Tarrawonga Coal Mine (MP11_0047-Mod-7): Adequacy of Environmental Assessment

The Resources Regulator advises the Department of Planning, Industry & Environment – Resources Assessments that the SEARs for Rehabilitation have not been adequately addressed in the Tarrawonga Coal Mine Life of Mine Modification 7 for Project Tarrawonga Coal Mine

On Review of the Tarrawonga Coal Mine Life of Mine Modification 7, the Resources Regulator requests further information in relation to the key points listed below.

Figure 4 - pit crest general arrangement (Modification report, Figure 2-2)

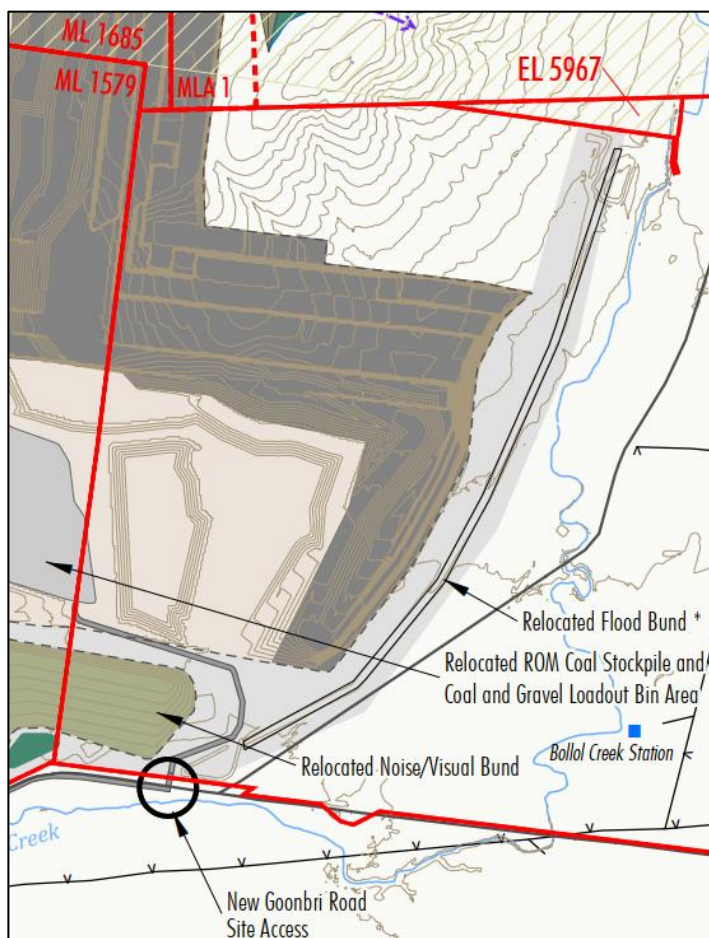
- As shown in Figures 2-1 and 2-2, the indicative active mining and waste rock emplacement areas are in excess of 500m to 1500m wide behind the active mining strips and there appears to be minimal areas available for progressive rehabilitation from Year 3 to Year 7. As such, the Regulator seeks further information as to whether the progressive rehabilitation schedule can be advanced between these years. In addition, further detail is required in regards to the progressive rehabilitation scheduled proposed beyond Year 7 until the cessation of mining operations.
